YorkshireWater

Your Ref: 2020/91468
Our Ref: W007244

Former North Bierley Waste Water Treatment Works Oakenshaw - Discharge of conditions 5 (Phasing Plan), 11 (Sewer Overflow), 13 (Foul Water Drainage), 14 (Discharge of Surface Water), 23 (Flood Risk) and 24 (Disposal of Surface Water) on previous permission 2016/92298 for outline application for re-development of former waste water treatment works following demolition of existing structures to provide employment uses (use classes B1(c), B2 and B8)

DRAWING NO: 1856 PL 156 B

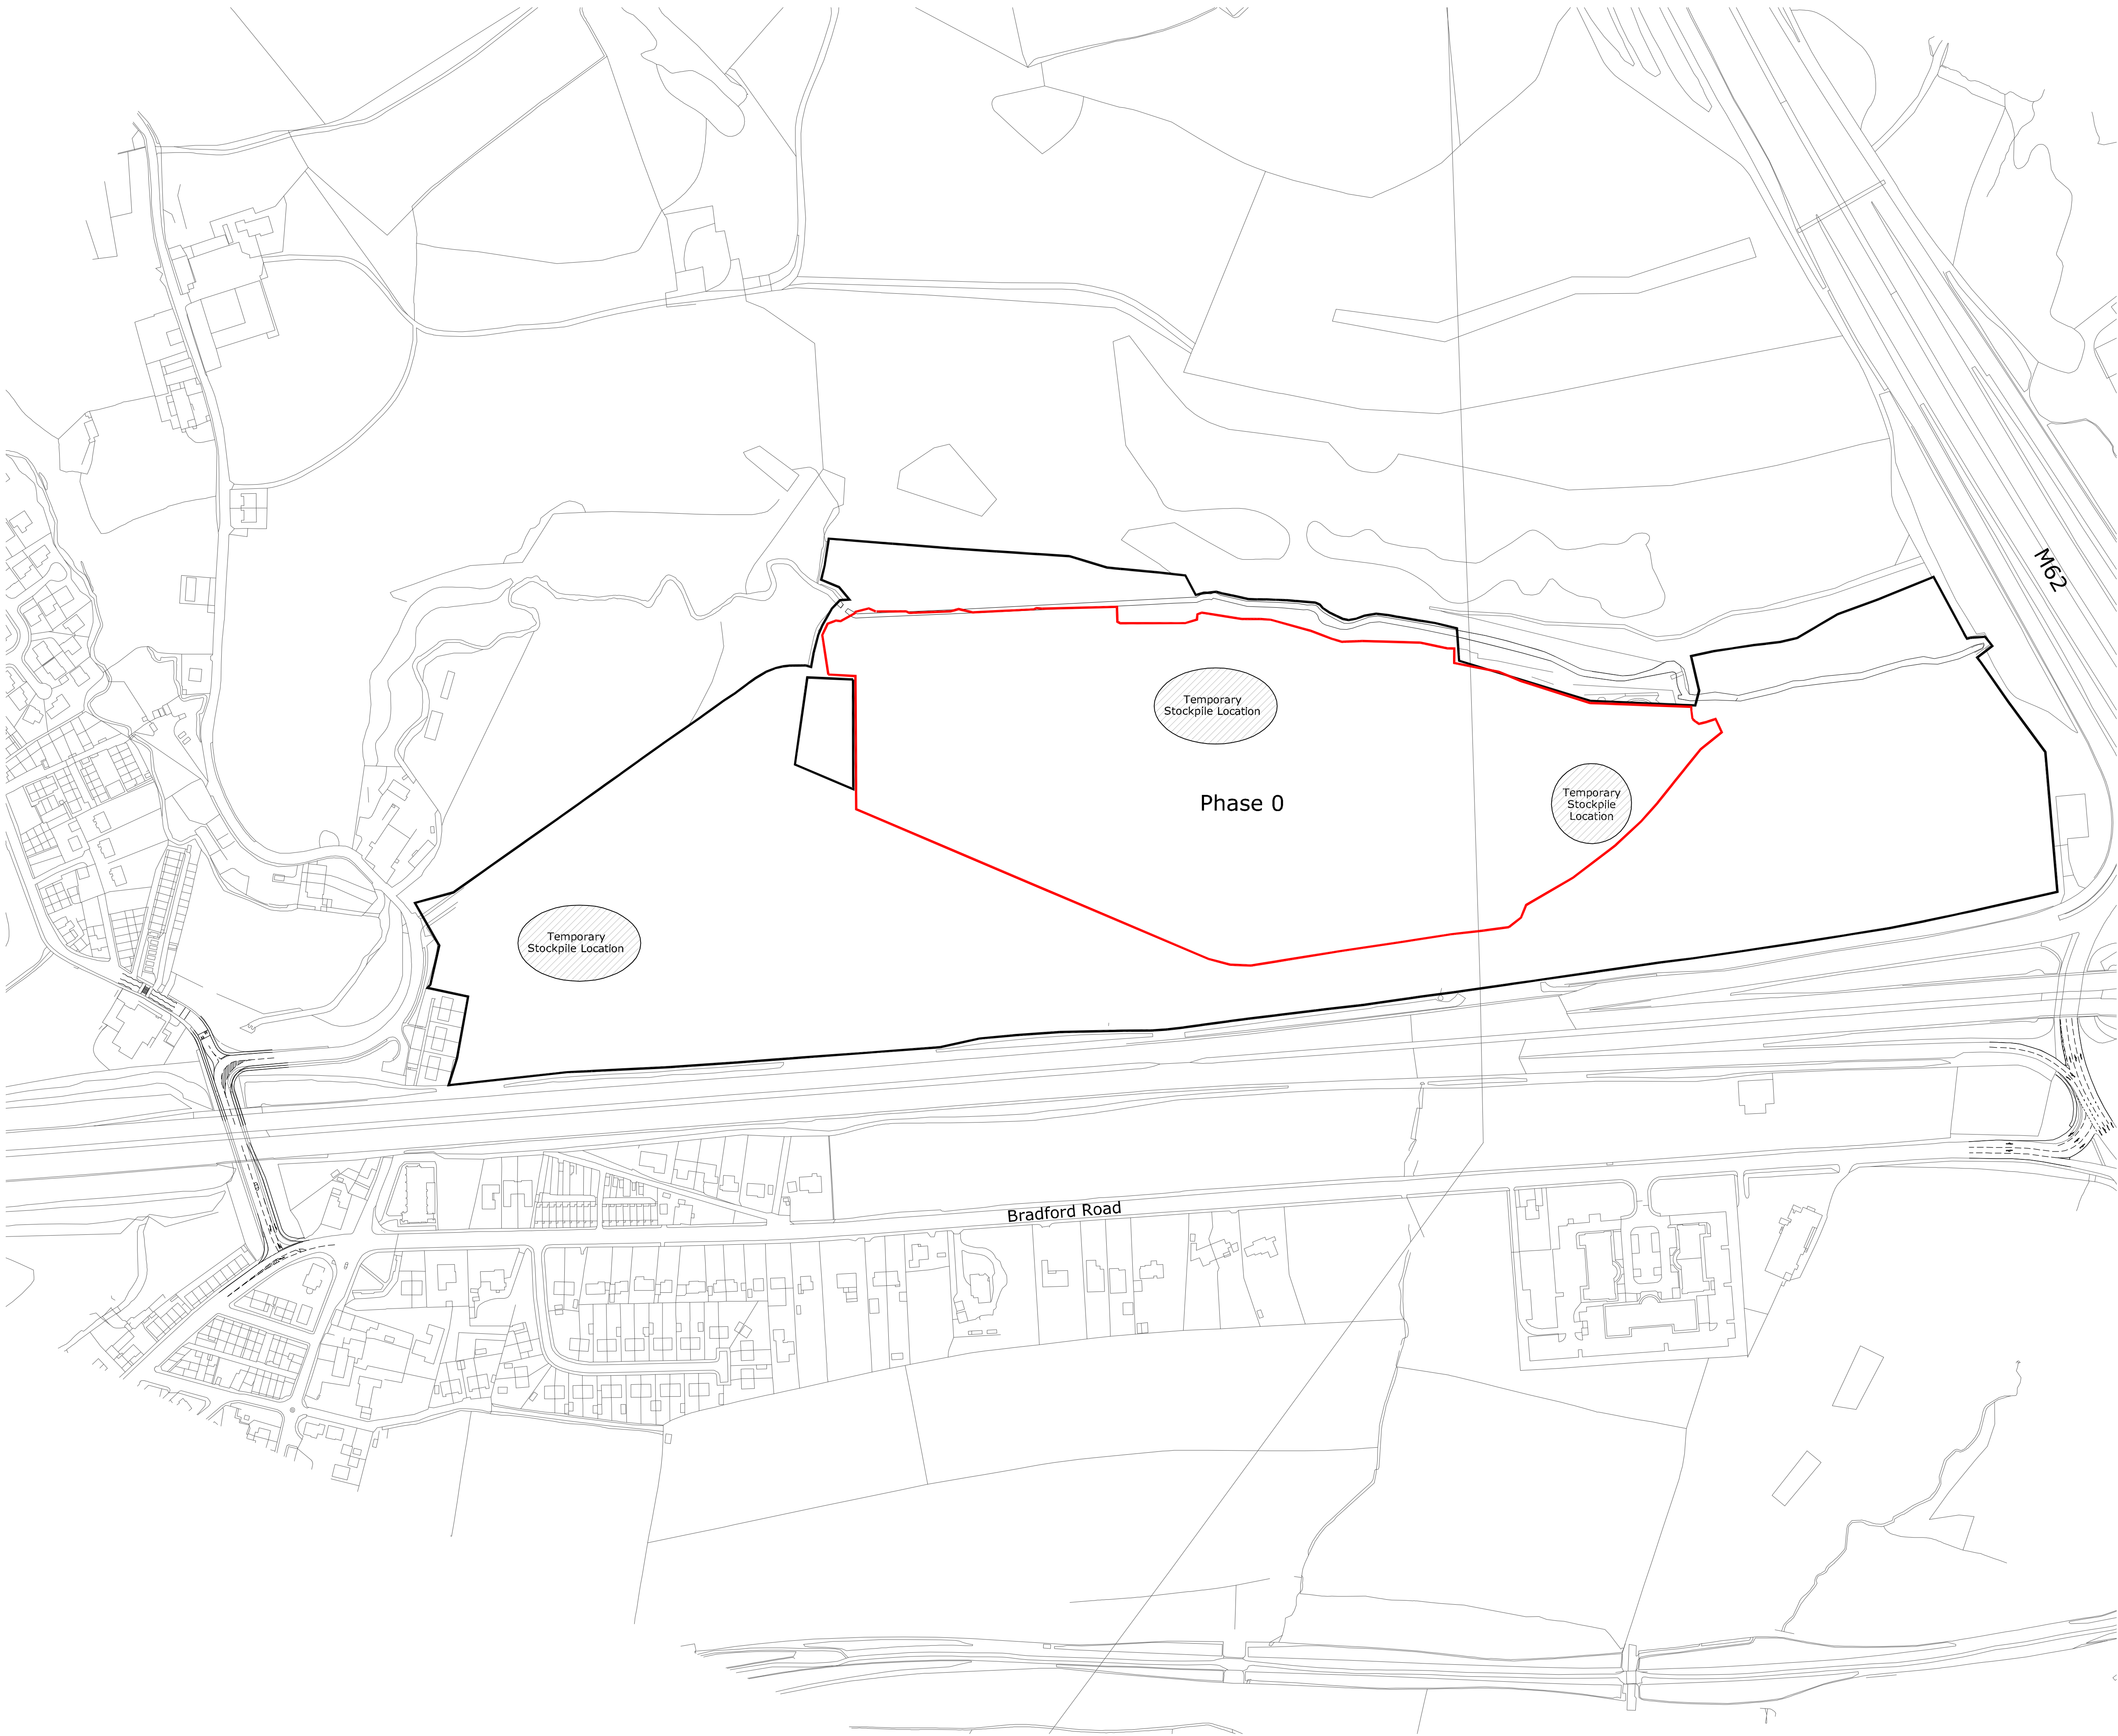
1) The submitted phasing plans on the email are satisfactory and although the submitted drainage plans require amendments, from the emails directly from the developer, it is clear that the intention is to pump foul water at maximum rate of 3.5 (three point five) litres per second to the public combined sewer crossing the site.
